Arcadis Australia Pacific Pty Ltd
Level 16, 580 George Street
Sydney NSW 2000
Tel No: +61 2 8907 9000
www.arcadis.com/au

1/05/2019

**Re: Cairncross Waste Management Facility Expansion SSD 5792
Response to Submissions**

Figure 1-2 Site layout

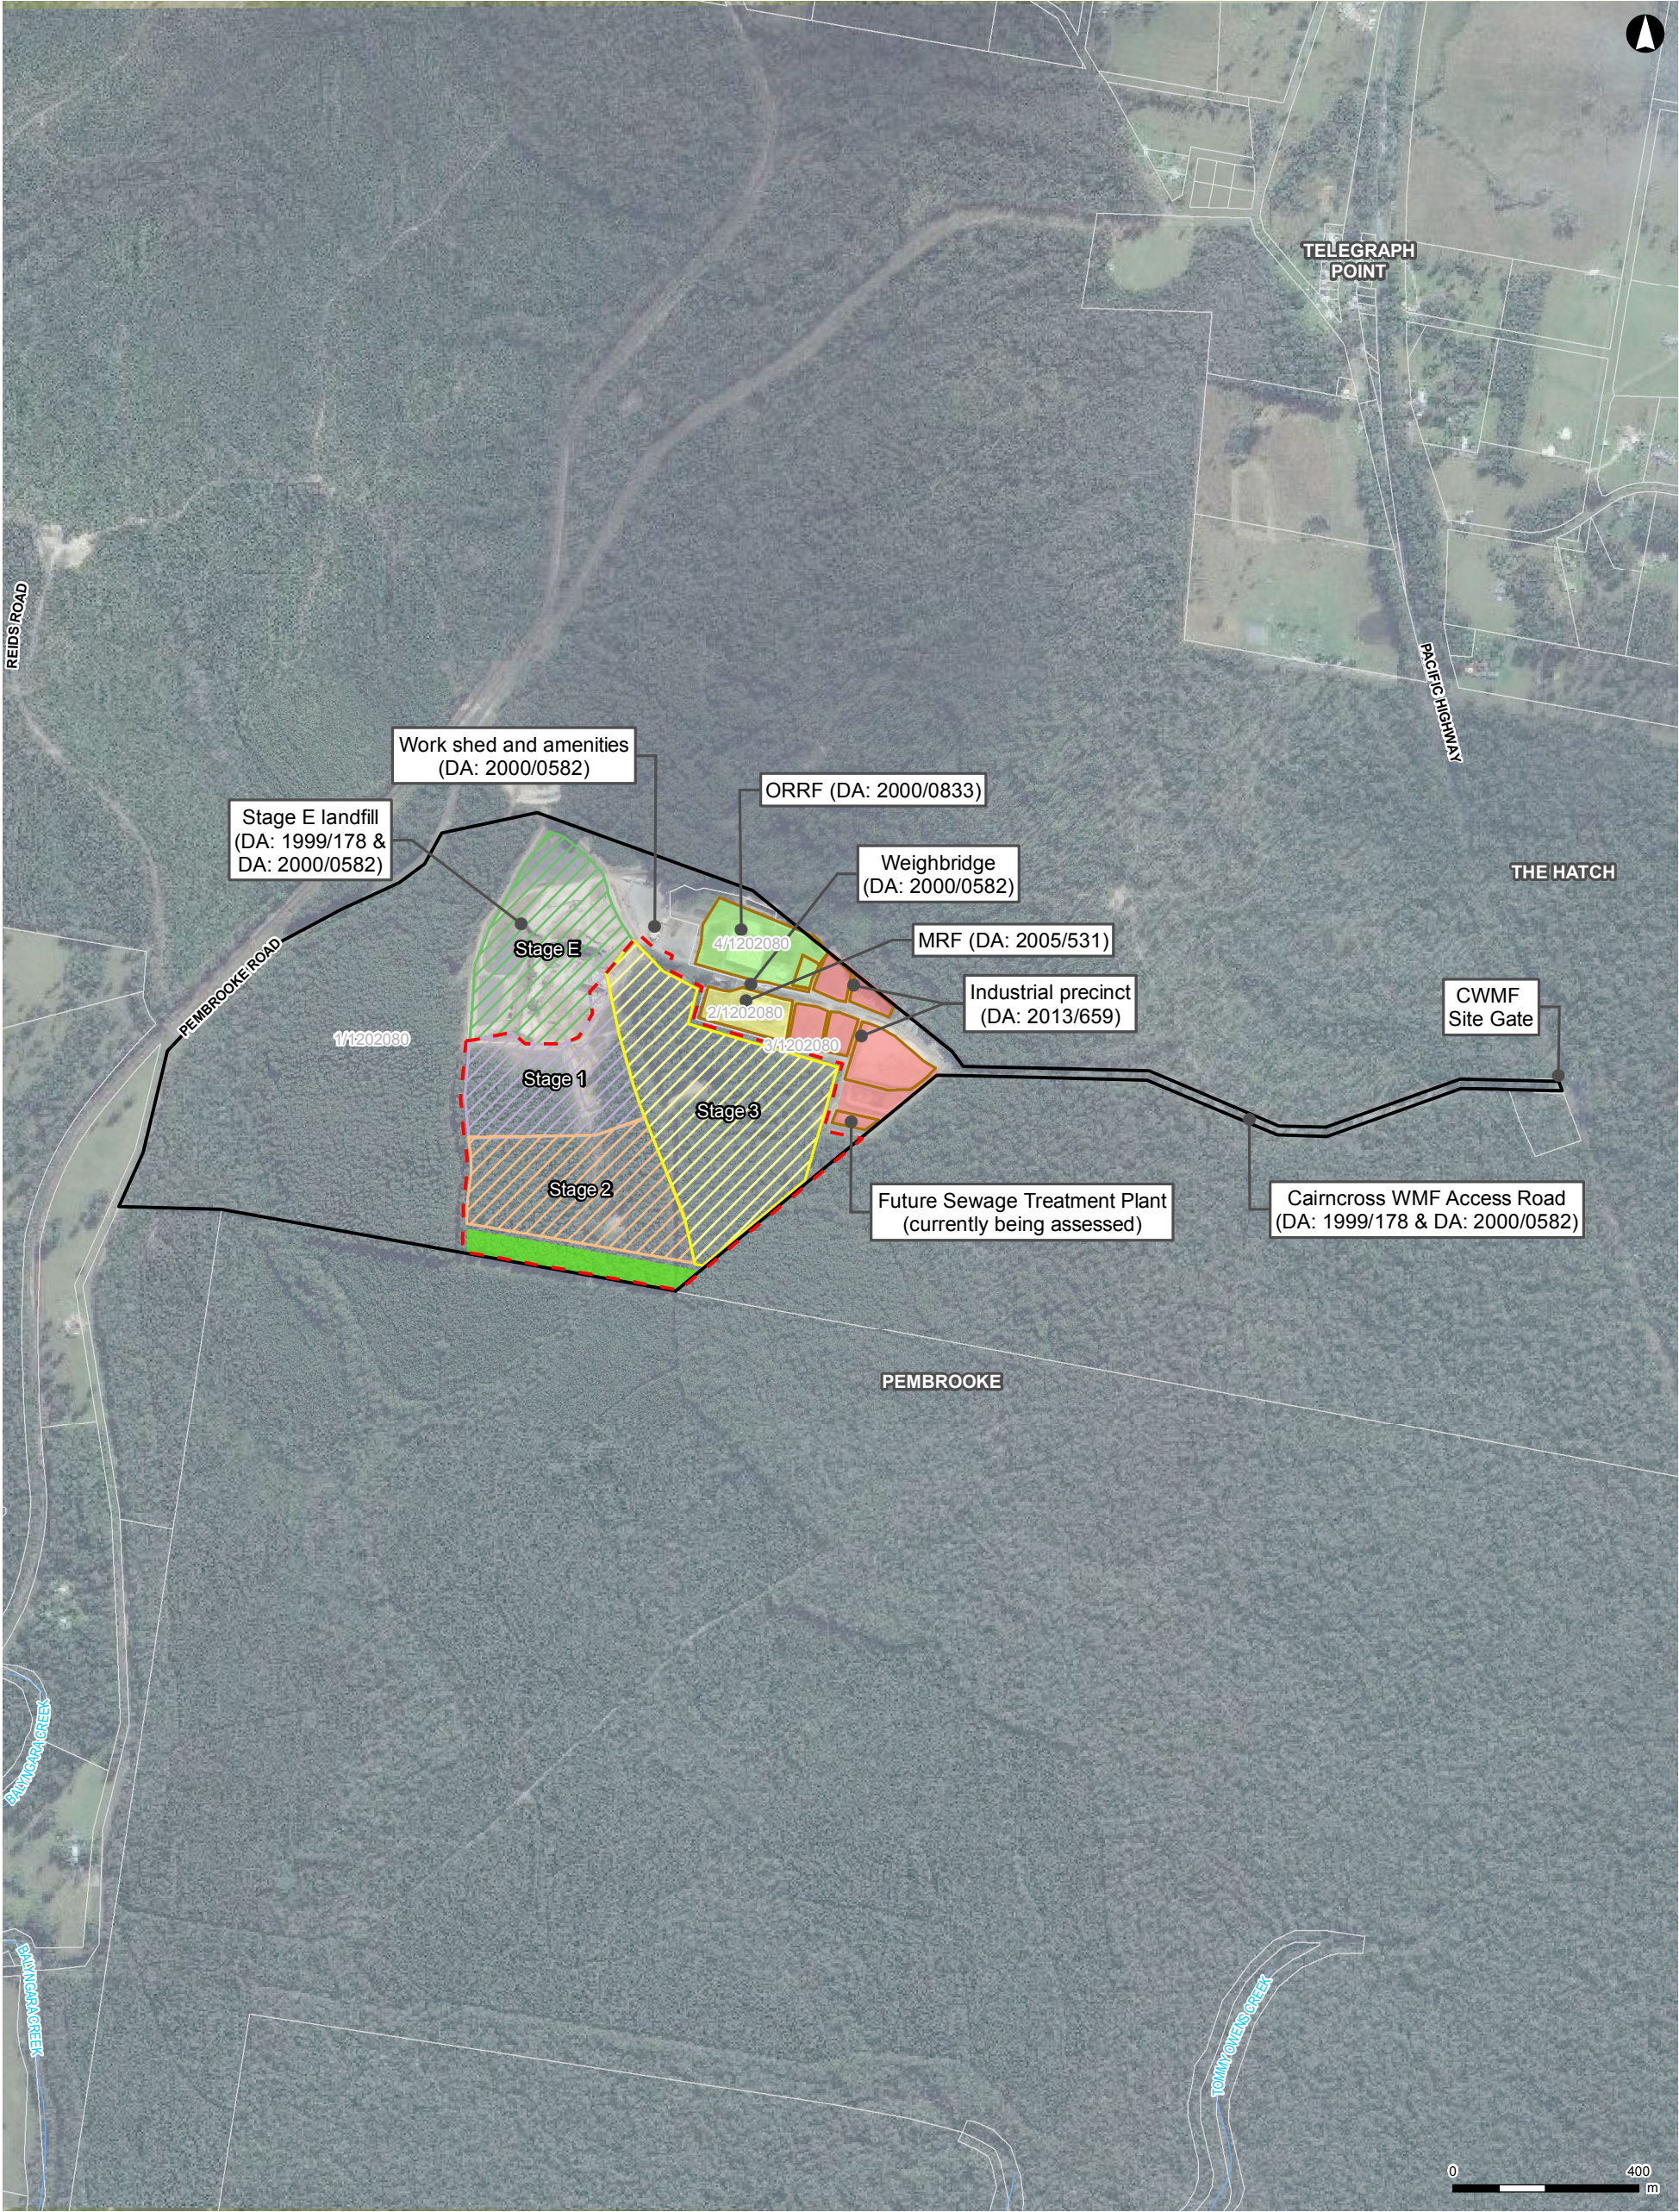
The OEH also recommended the sediment basin, leachate tank and pump station (approximately 163 m by 20 m in size) be located outside the 50 m wide koala corridor in the Stage 2 and Stage 3 development. This has not been implemented.

While [OEH] note that the basin will be reduced in size over time and will be removed following rehabilitation there is inadequate justification that the remaining 20 m will provide enough area for fauna movement. The OEH does not consider the basin and the associated infrastructure to be compatible with the objective to provide an adequate corridor for koala and other fauna movement and it will prevent the effective revegetation and restoration of this area.

The Stage 2 sediment basin is located outside the koala connectivity corridor, with the boundary fencing and access/fire trail located between the basin and the koala corridor. It is noted however that the Stage 2 sediment basin will likely need to encroach into the koala corridor by 30 m, over a length of approximately 163 m. It has been identified that this effect would create a localised 'squeeze

point' within the corridor. It is however expected that the remaining 20 m would provide sufficient area for fauna movement, for the following reasons:

- The portion of corridor that would be narrowed under the Amended Proposal would be limited to areas bordering the sediment basin. This basin would naturally provide an additional buffer to the corridor from potential impacts associated with active landfill activities, including noise and vibration, litter migration, light spill, odour and the introduction of weeds.
- The extent of narrowing is considered to be minor (30 m reduction over a 163 m span), and the remaining corridor area would be subject to ongoing management within the Vegetation Management Plan (refer to Mitigation Measure FF-11).
- The koala corridor is unfenced on the southern side, and the Extension Road is a forest track that rarely has traffic. While this road has no vegetation, this track could be used if necessary, thereby effectively reducing the 'squeeze point' generated through presence of the basin.

It is also noted that this sediment basin will decrease in size over time and will be removed following rehabilitation of the landfill and is therefore considered temporary in nature. In the initial year, following installation of the sediment basin, the basin would be wholly contained within the Stage 2 area and would only encroach on the koala corridor once landfill within Stage 2 has substantially progressed. The sediment basin sizing can potentially be refined to extend the width of the koala corridor post-closure (i.e. once Stage 2 is rehabilitated).

The Amended Proposal currently allows for the development of a koala habitat linkage corridor 50 m wide at the southern end of the proposed extension. The corridor will be bound by the proposed extension to the north and Extension Road (a minor dirt road) to the south. State forest is located to the south of Extension Road. The aim of retaining the koala corridor is to facilitate continued movement of koalas between larger patches of habitat to the east and west following removal of vegetation for the Amended Proposal. It is acknowledged that the koala corridor will be temporarily "squeezed" to a width of 20 m for a length of approximately 163m. The 20 m width is considered adequate to facilitate koala movement for a number of reasons, outlined below.

- The distance where the corridor would be pinched is considered to be a small distance (163m). Koalas are known to traverse distances of 3 to 4 km between habitat patches, often across substantially more cleared area than the proposed koala corridor.

- The koala corridor and adjacent areas are absent of regular traffic or pet dogs, both of which are considered to be the most significant threats to koalas while traversing the ground between trees.

- Only the understorey would be cleared for bushfire protection. The need to prevent canopies from touching can be avoided via diligent clearing of understorey allowing a high density of trees to be achieved. Koalas would have access to trees to ascend in the event of a danger becoming present. Given the density of trees within the proposed koala corridor, koalas would not have large areas to traverse in the event of danger before reaching a tree. The koala corridor is proposed to be revegetated to enhance the biodiversity value of the corridor and to increase the density of koala feed trees throughout it. Revegetation of the corridor will commence upon approval of the Amended Proposal during the Stage 1 landfilling activities. While the corridor is being revegetated koalas will be able to traverse both the corridor and the existing vegetated area within the Stage 2 landfill cell (north of the corridor) which has a higher density of vegetation. The

corridor will therefore have had approximately 20 years of revegetation prior to it becoming the primary koala corridor ensuring adequate vegetation coverage for use of the corridor by koalas.
